Vista Oakland Subdivision

RE: Vista Oakland Subdivision (File: C19D059)
Grading and Drainage Plan, Engineer's Stamp Date 8-30-2013
Engineer's Certification Date: 7-26-16

**Re: Vista Oakland Subdivision, Grading and Drainage Plan
Engineer's Stamp Date 8-30-13 (C19D059)**

**Re: Lots 1-a, 1-B, 1-C, 3 Lot Subdivision SE corner of Oakland and Louisiana
Grading and Drainage Plan
Engineer's Stamp date – no stamp-(C19D059)**

CITY OF ALBUQUERQUE  
PUBLIC WORKS DEPARTMENT  
ENGINEERING DEVELOPMENT GROUP  
**VISTA OAKLAND SUBDIVISION**  
BEING A REPLAT OF LOT 1, BLOCK 3, UNIT 3, TRACT 2, NAA  
GRADING & DRAINAGE PLAN

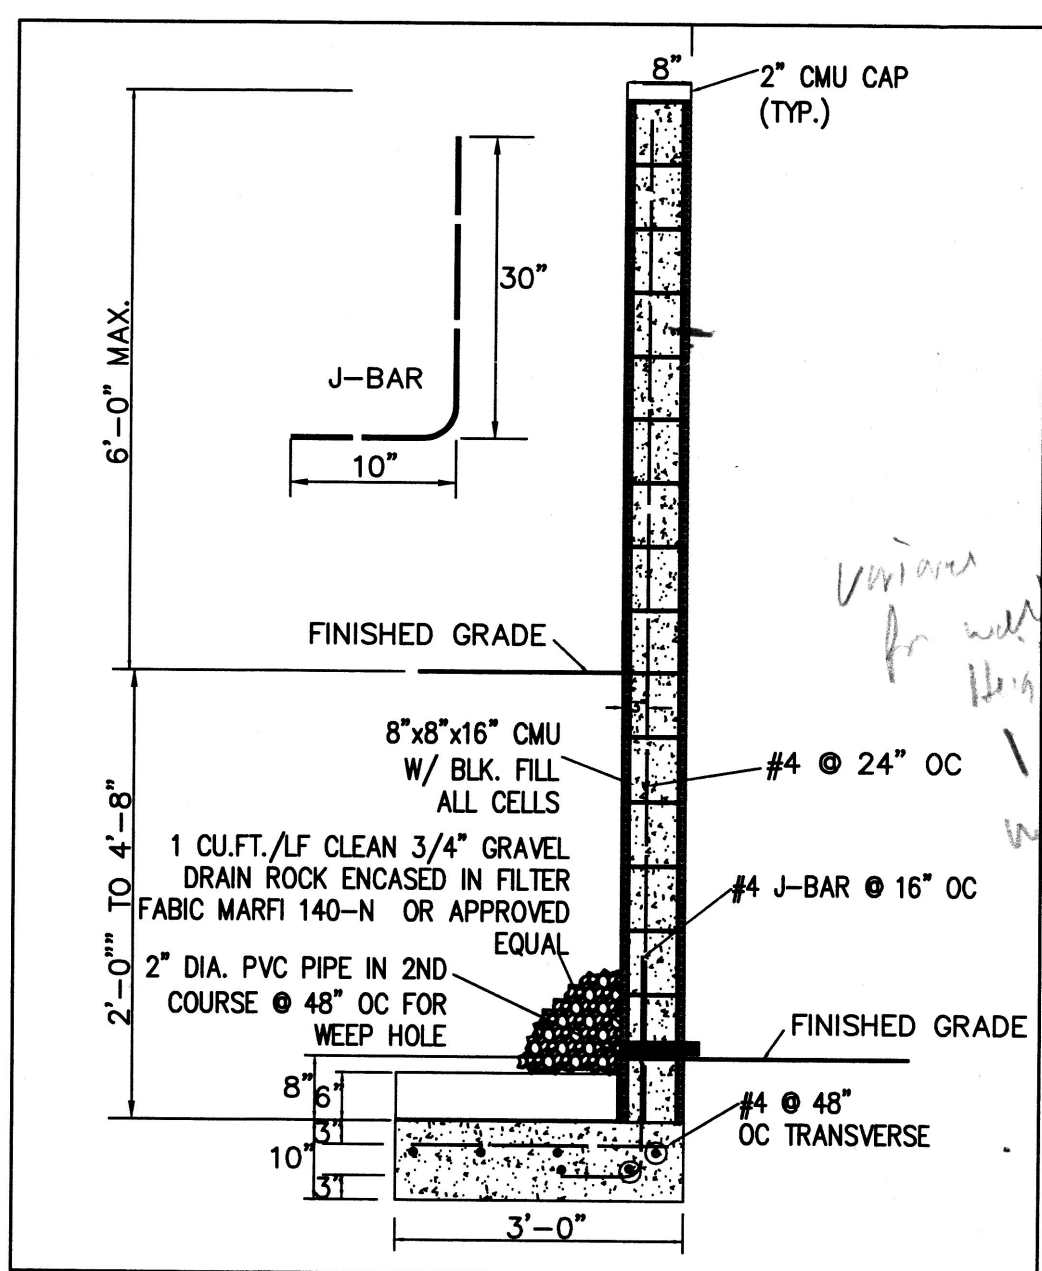
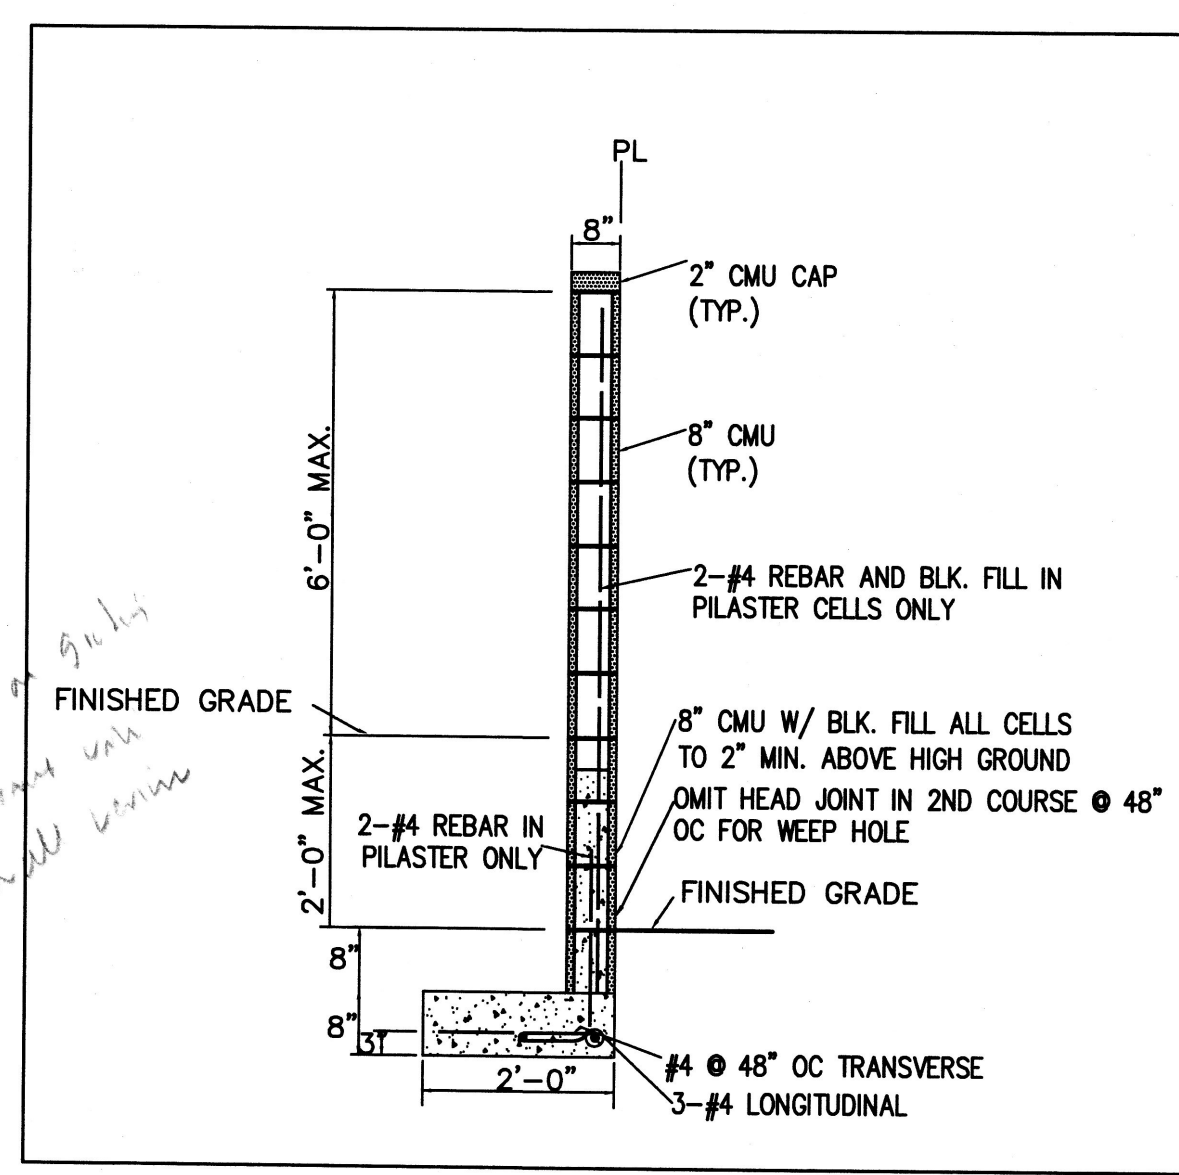
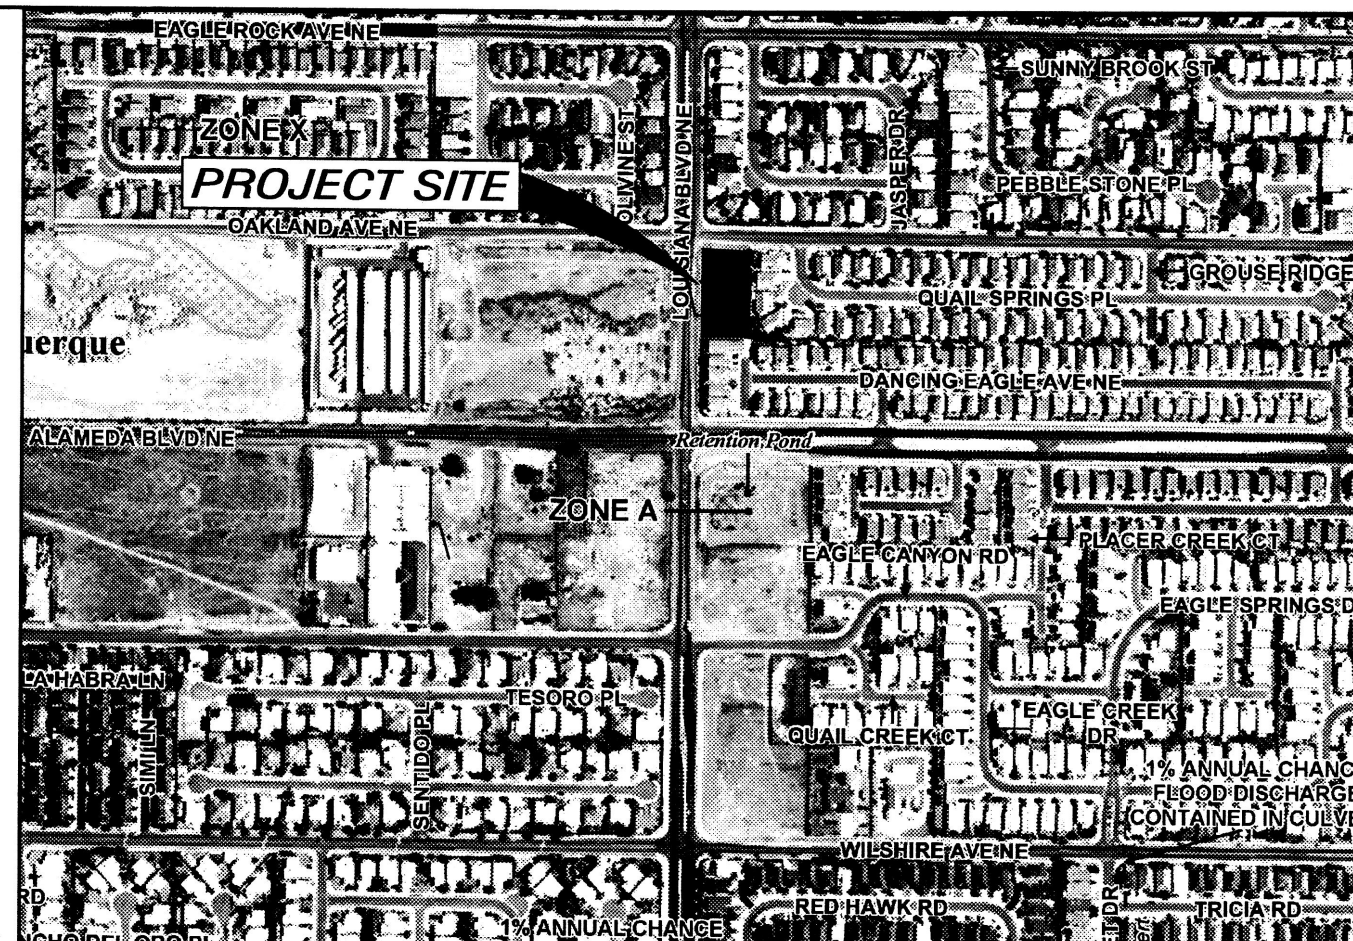
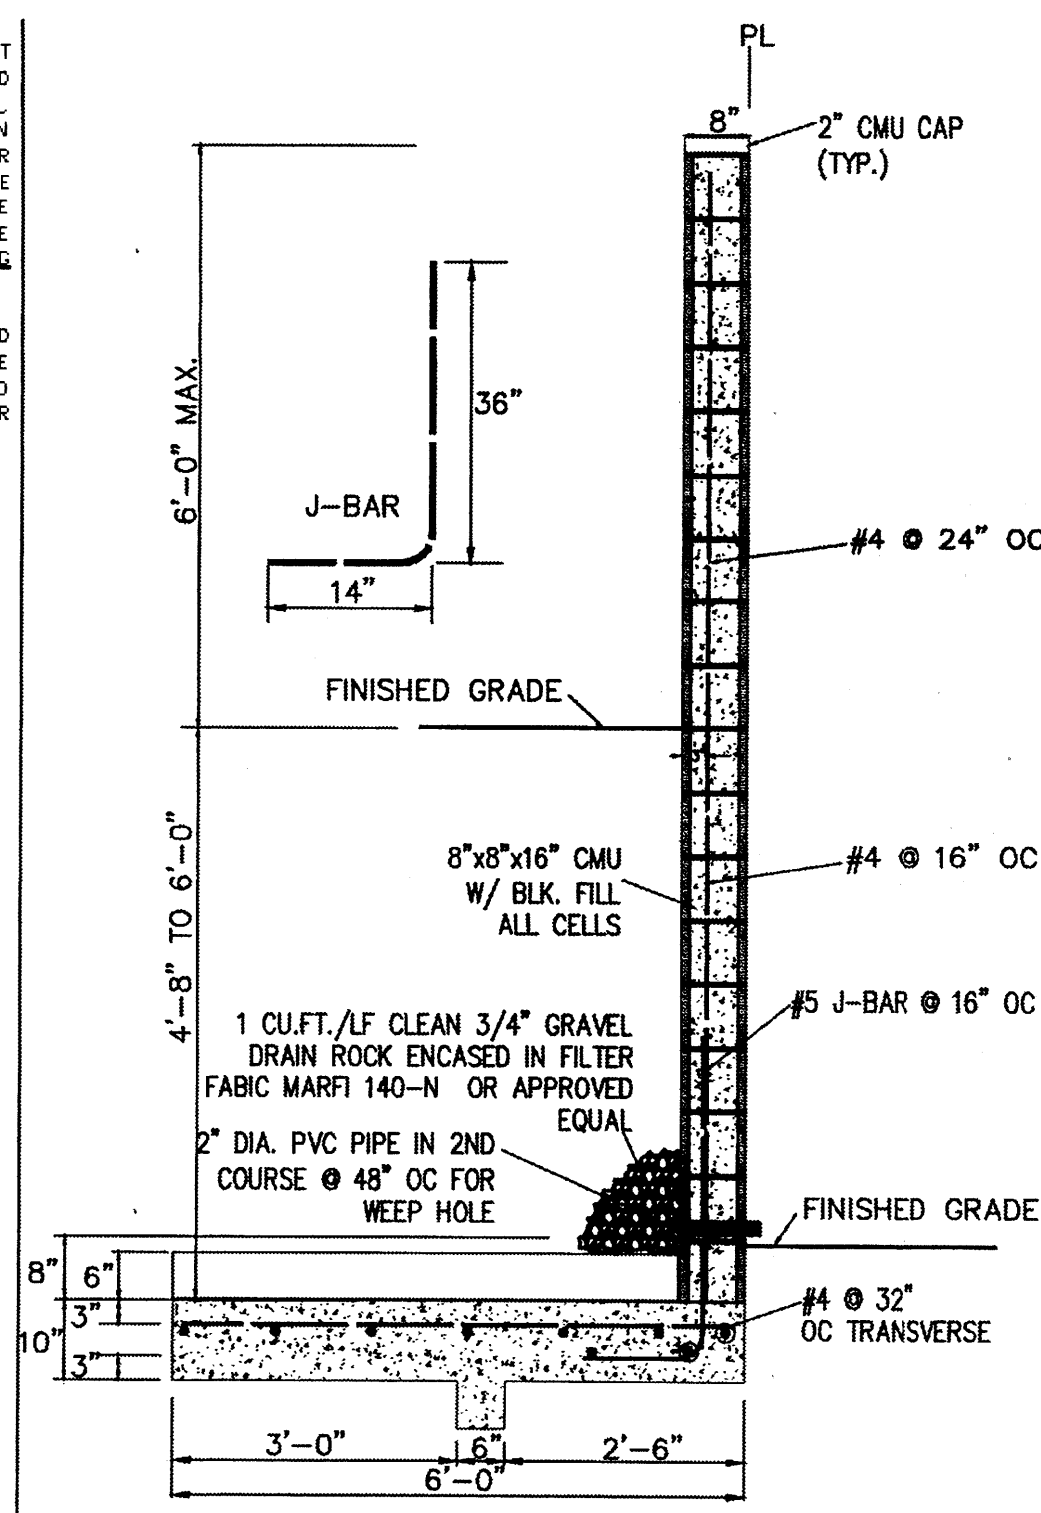
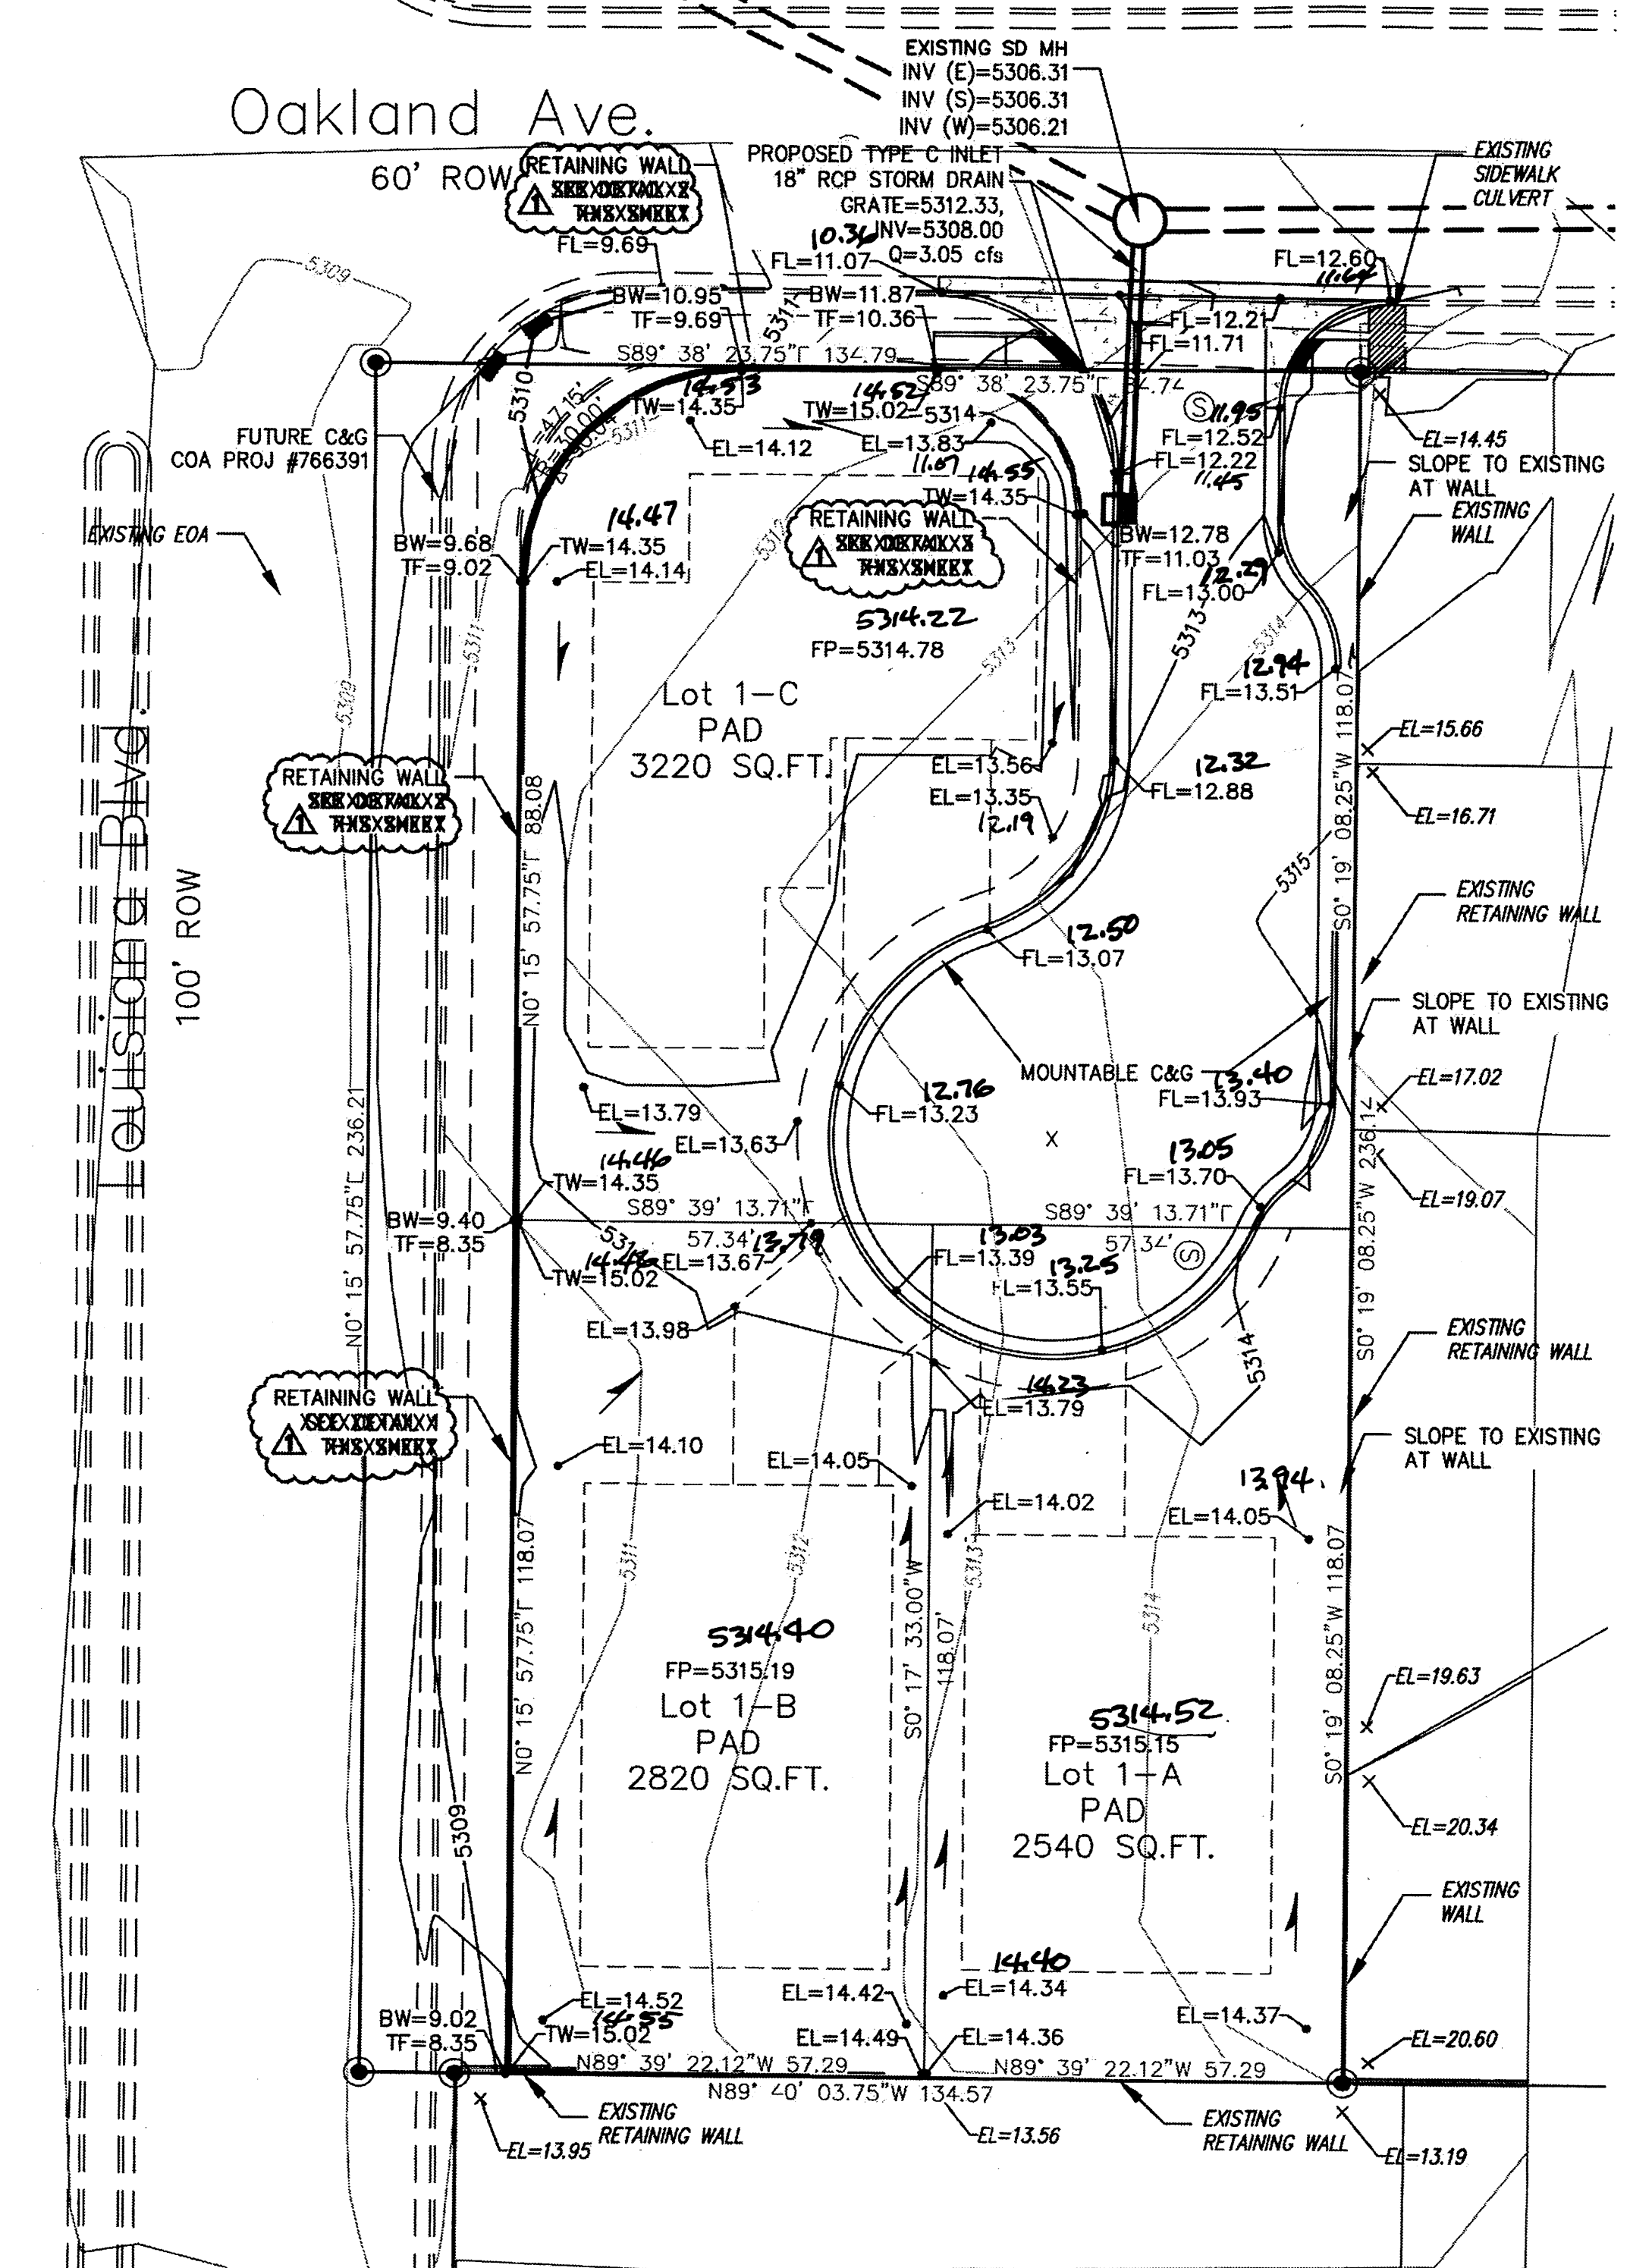
1. The curb along the eastern side of the street should be standard curb and gutter and depressed standard curb and gutter. Depressed standard and standard curb and gutter will help since access is not required along the eastern curb line and the taller curb will help prevent sediment from entering the street and storm drain as well as help to not disturb the footer of the existing wall.

2. The transition from mountable to depressed standard curb and gutter can occur within Lot 1-A.

1. The Quail spring Subdivision Pond Reclamation grading plan, C19D015A, shows 2-6" (? , not extremely clear) SDR 35 drain pipes extending to the face of curb in the area where the east curb return is proposed. How will drainage from these pipes be accommodated? Show relevant grade information.
2. Hydrology could not determine the bottom of wall elevation for the existing flood wall, not retaining wall, along the eastern edge of this subdivision. Since you are proposing lowering the grade on the downhill side, the footer may be exposed. Provide information regarding the elevation of the wall footer.
3. The plan is to be sealed by a licensed PE.

1. There is a sidewalk culvert approximately 1 foot from the eastern property line which conflicts with the construction of the standard curb return radius. A curb return with a radius of 15' is proposed for construction. It is desirable to develop the private entrance utilizing curb returns. The sidewalk culvert will not be disturbed or its operation affected.
2. The grading of the site will maintain the existing cover on the existing wall and will not affect its stability.
3. The plan has been sealed by a licensed PE
